Outline application with some matters reserved for the erection of up to 160 dwellings with public open space, landscaping and sustainable drainage systems (SuDs), vehicular access point from Arundel Road together with up to 557 square metres of B1/B2 units with associated parking provision & vehicular access point from Arundel Road & land made available for expansion of current sports pitch provision to form a sports-hub (following the demolition of existing commercial units and one bungalow) (resubmission following A/36/18/OUT). This application is a Departure from the Development Plan.

Land off Arundel Road Angmering

Thank you for your internet representation made on 28th September 2019 which has been recorded as **'an objection'** with the comments as follows:

# PLAN 3

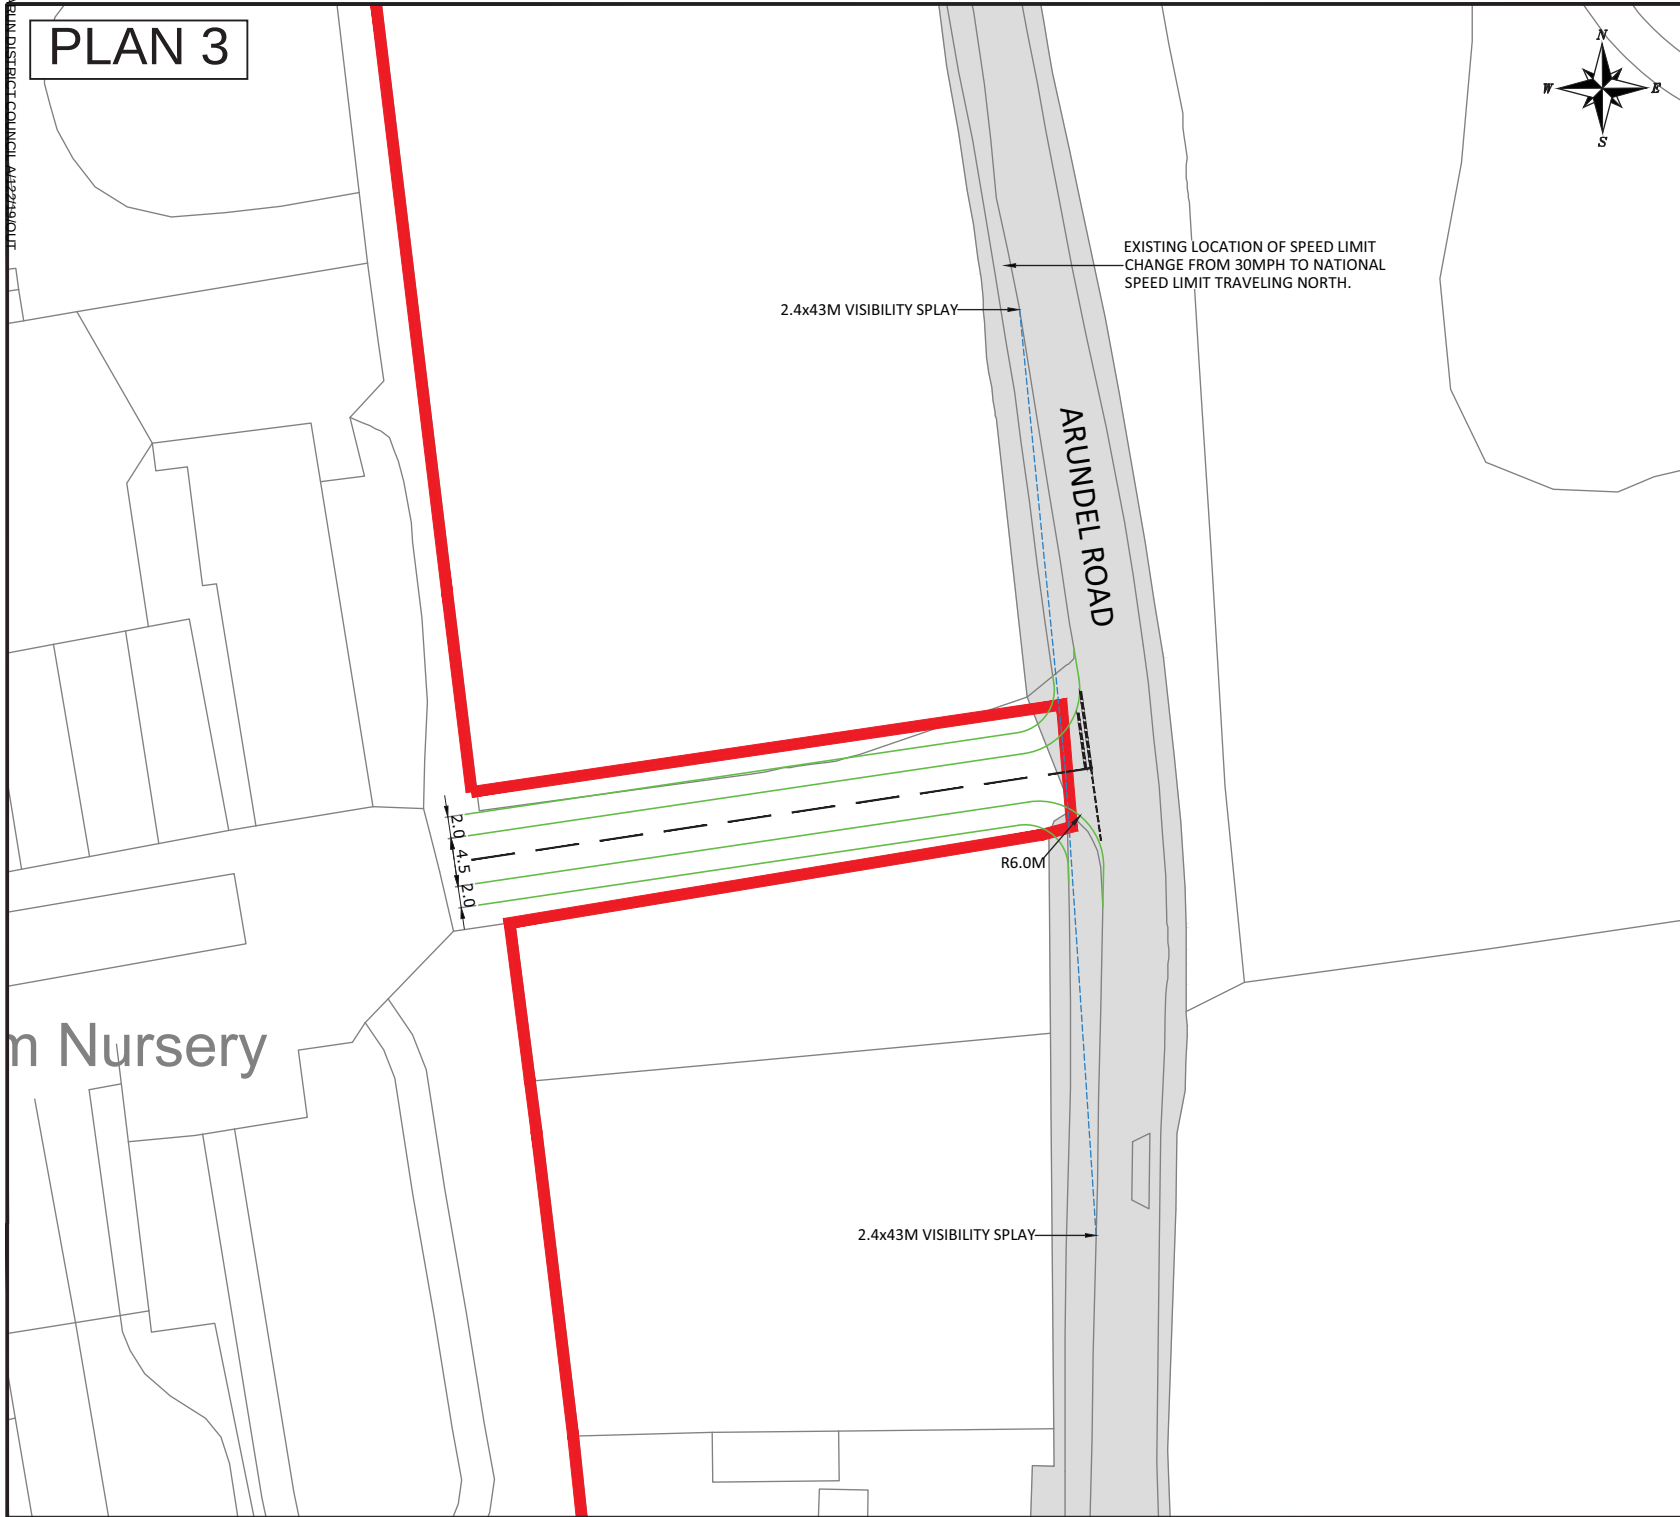
The current plan would require purchasing our 2 parking spaces within Decoy Drive. I have received no direct notification of this and would be curious as to where it is suggested the 30 cars using their own spaces would park?
